Qantas Flight Training Centre (SSD 10154) - Response to Submissions

Thank you for your correspondence dated 26 August 2019, requesting Transport for NSW (TfNSW) to review and comment on the above.

B99 VEHICLE SWEPT PATHS

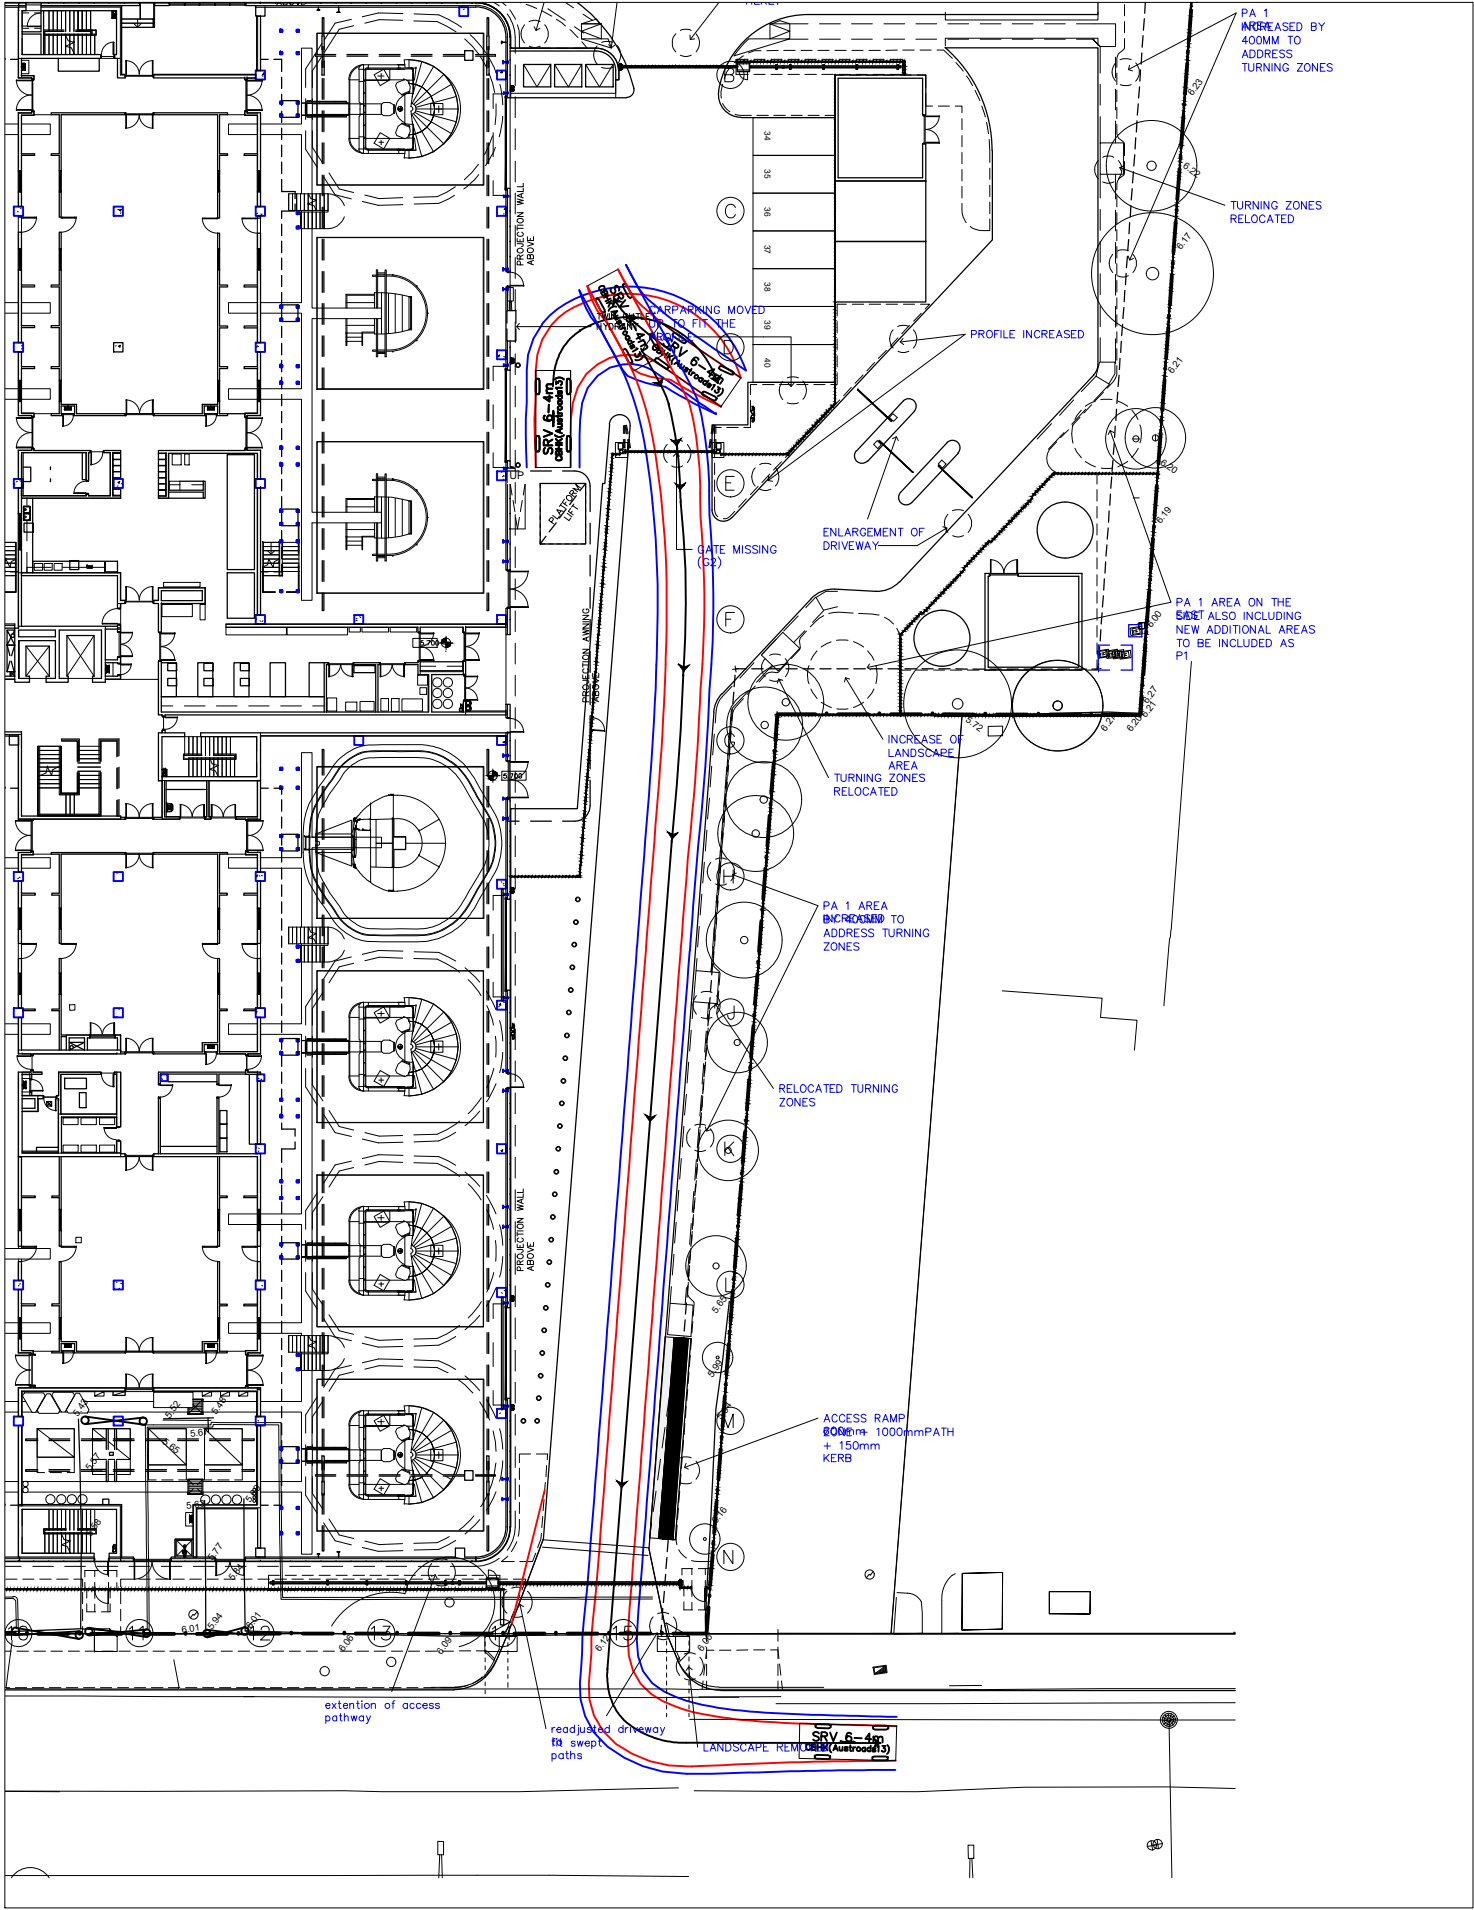
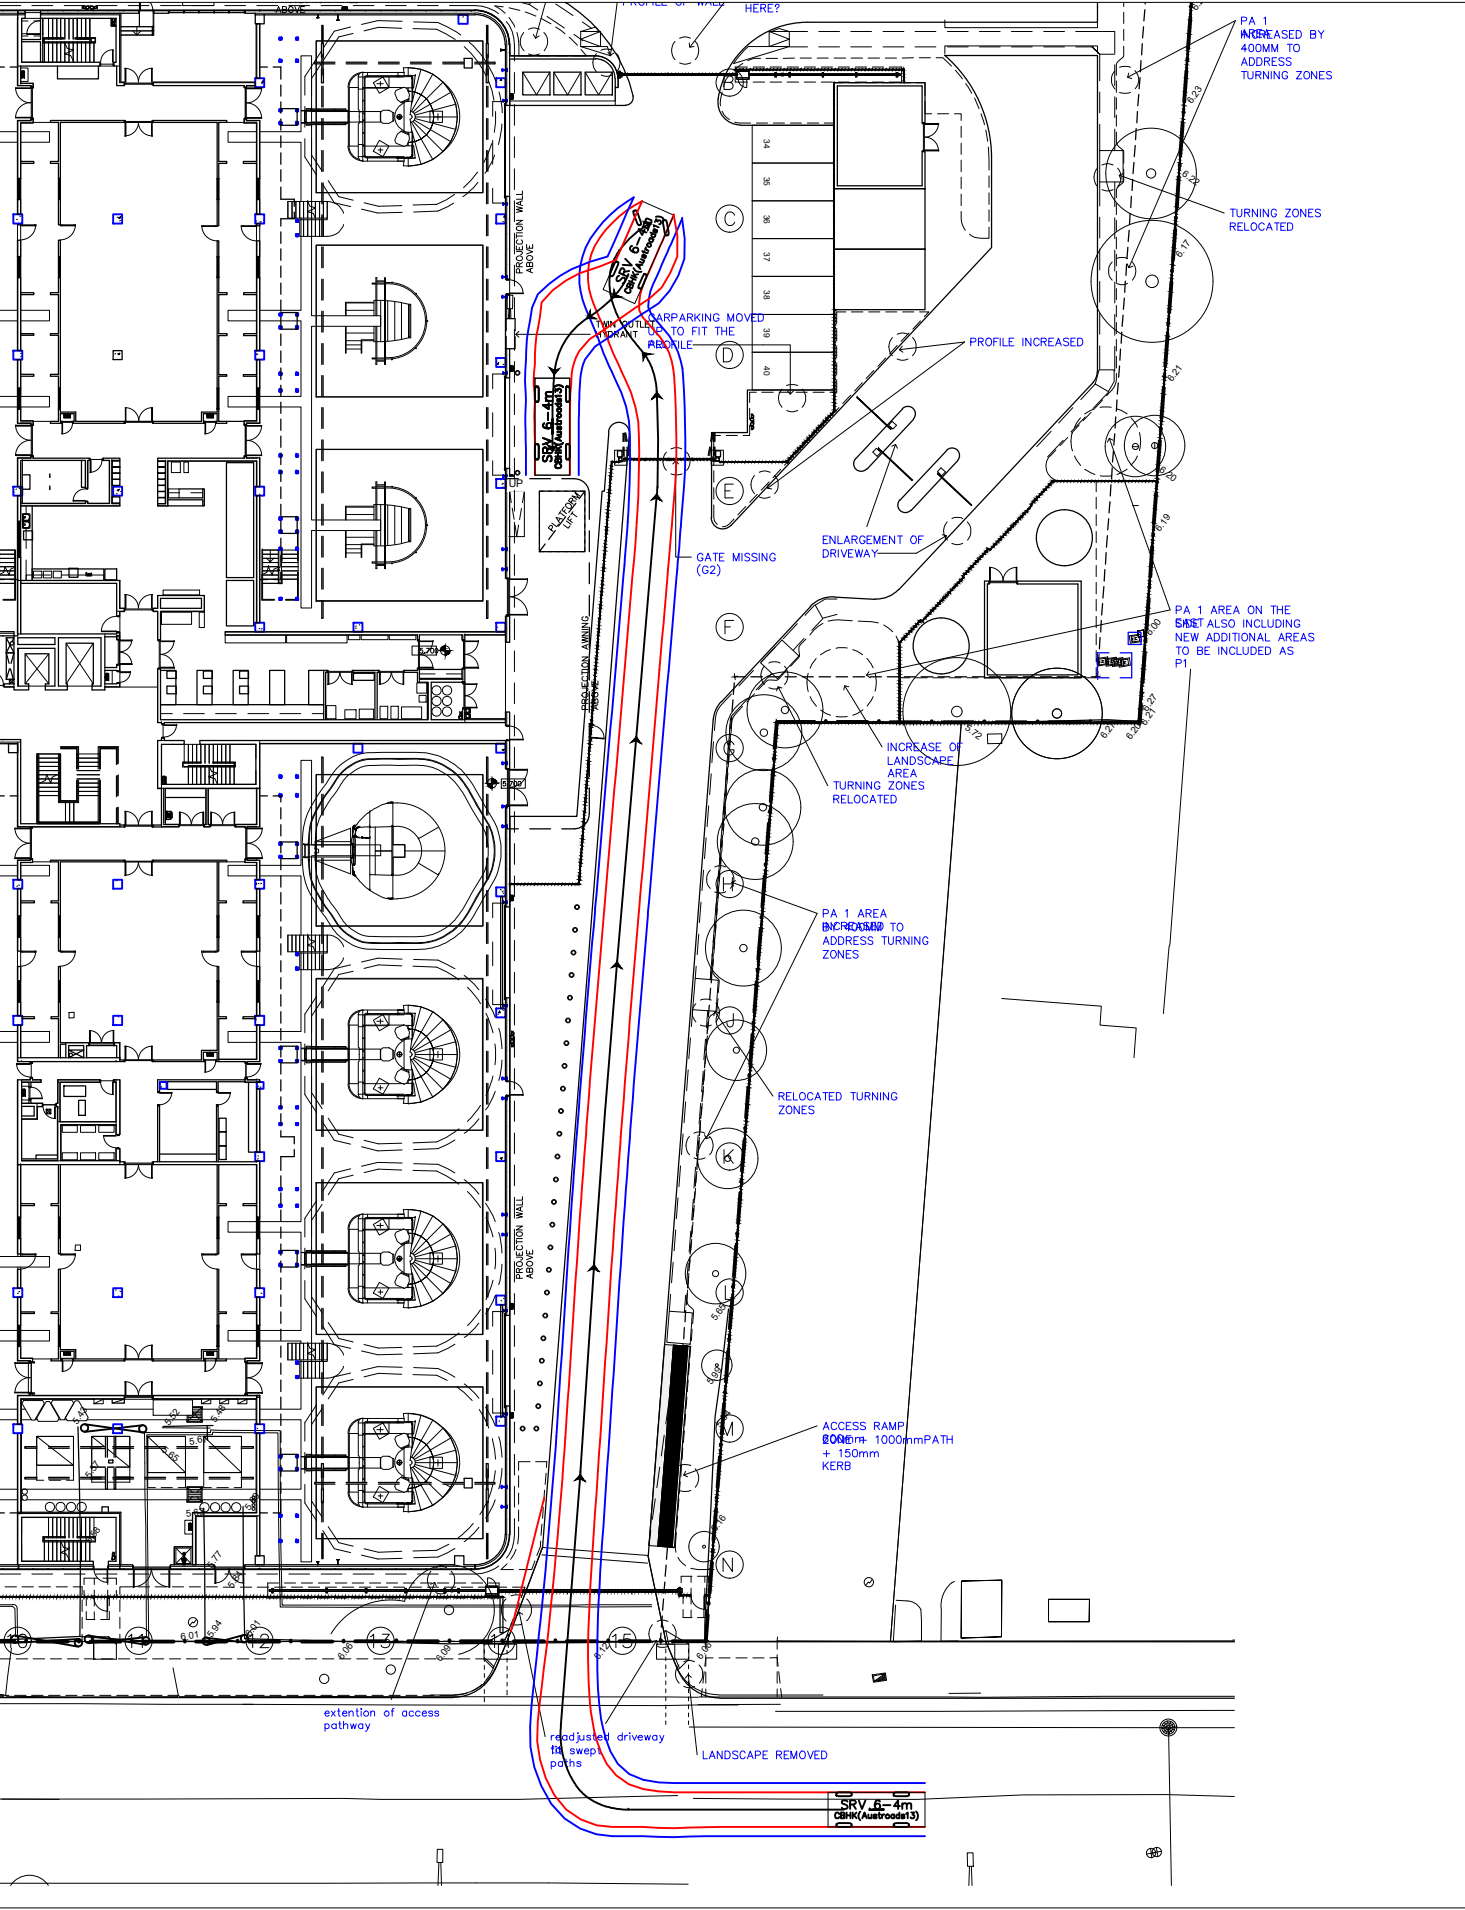
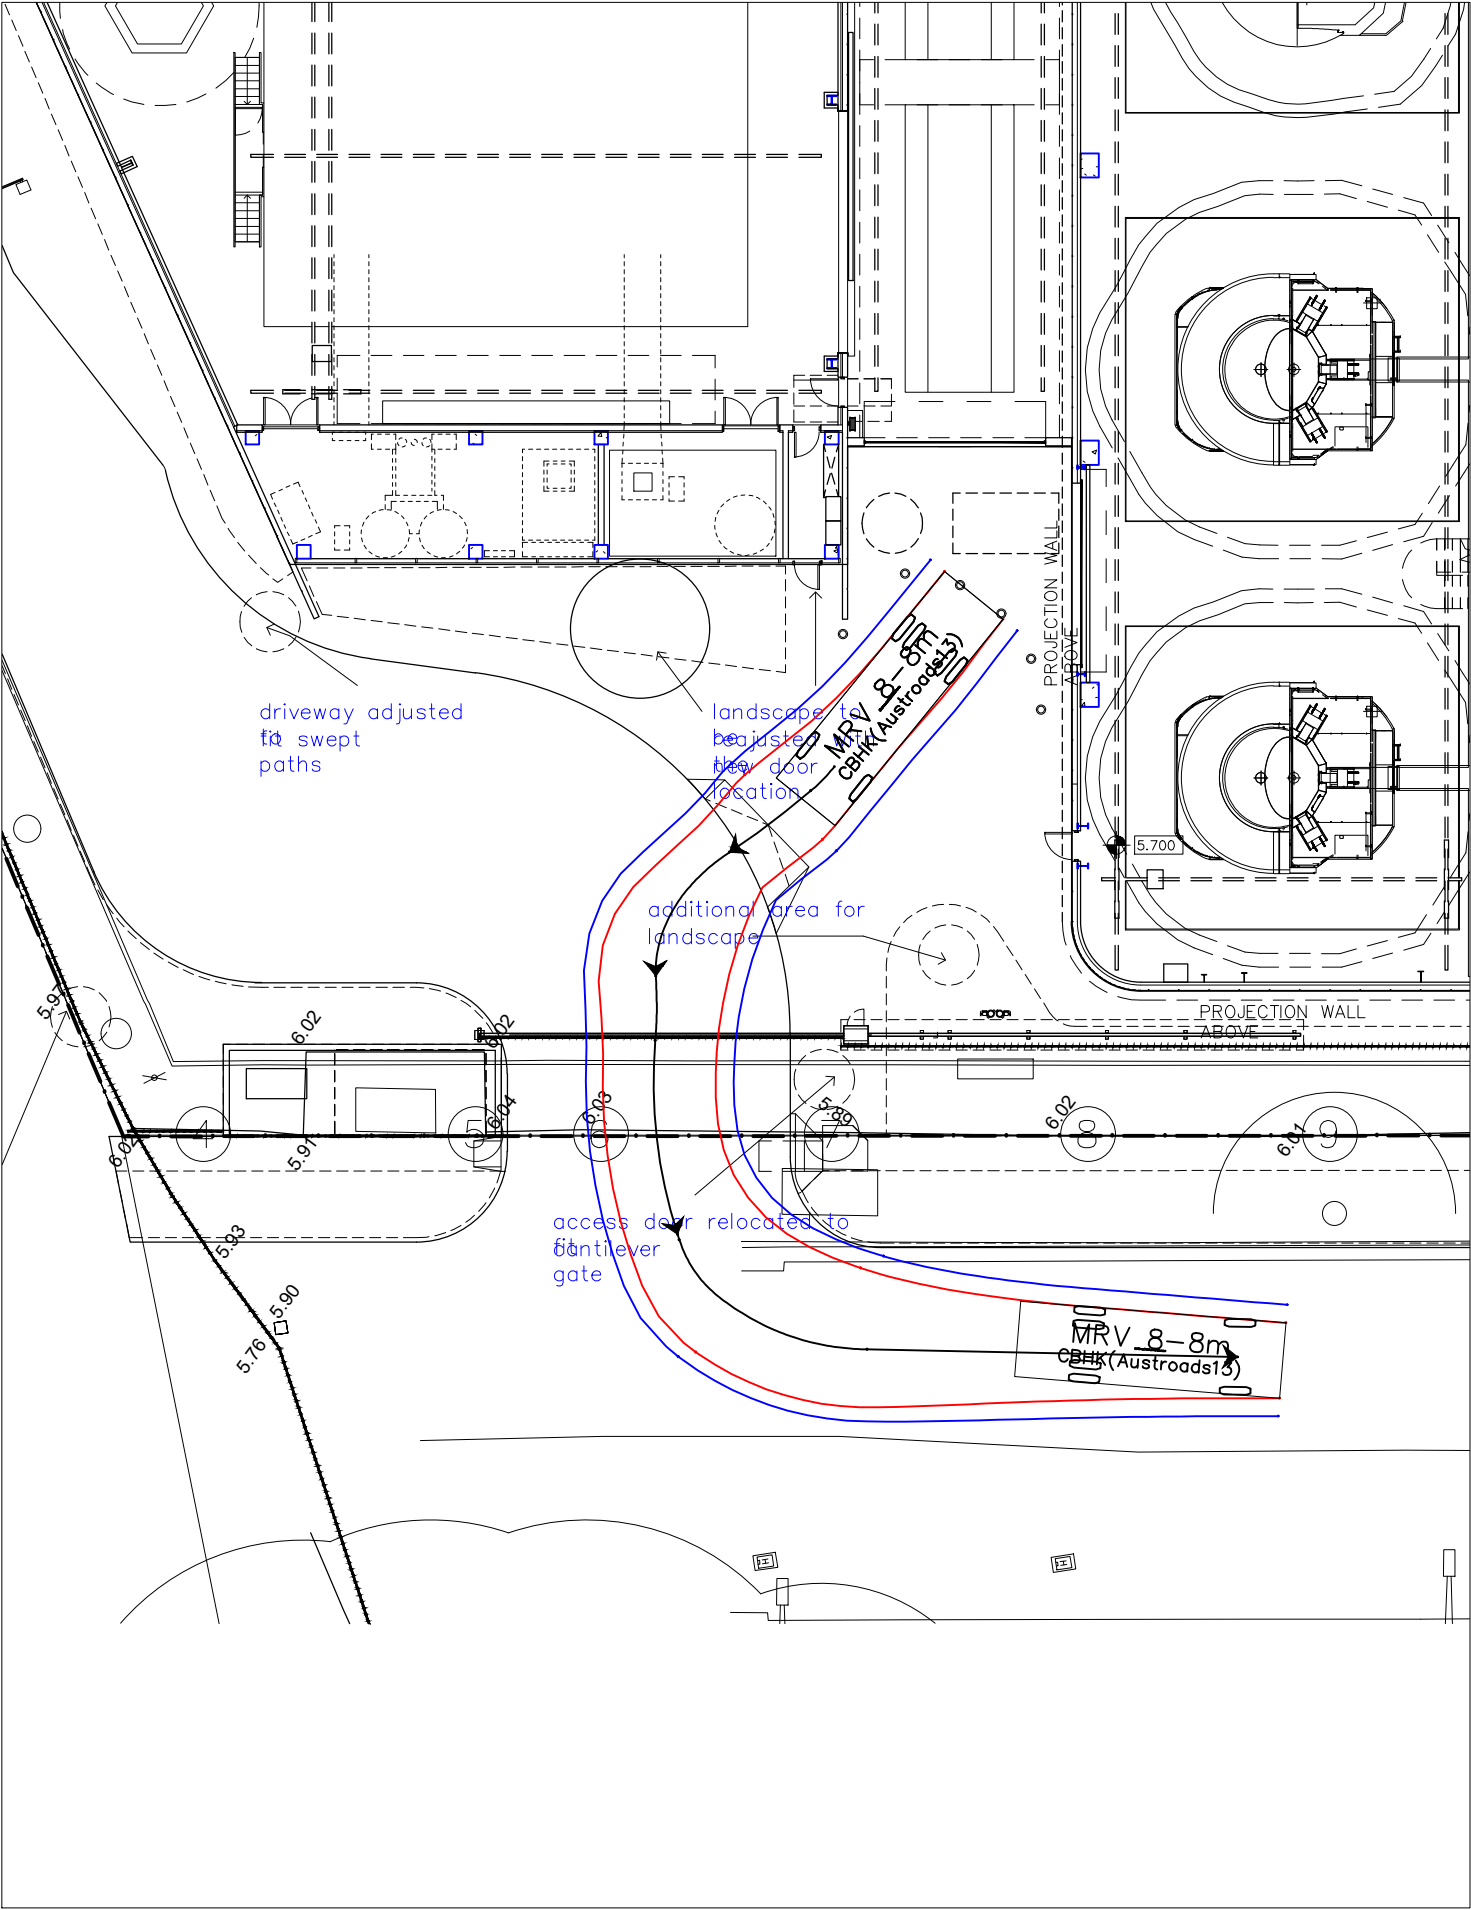
It is noted that the report mentions use of articulated vehicles. However, the swept path analysis includes a movement of a B-Double vehicle. If the proponent intends to run B-Doubles, a separate permit from the National Heavy Vehicle Regulator (NHVR) will be required. Any vehicle should arrive and depart the site in a forward motion.

It is requested that the applicant be conditioned to require all vehicles entering and leaving the site to do so in a forward motion. Note that if B-Doubles are intended to be used, a permit will need to be obtained from the National Heavy Vehicle Regulator (NHVR).

All vehicles entering and leaving the site shall do so in a forward motion. Note that if B-Doubles are intended to be used, a permit will need to be obtained from the National Heavy Vehicle Regulator (NHVR).
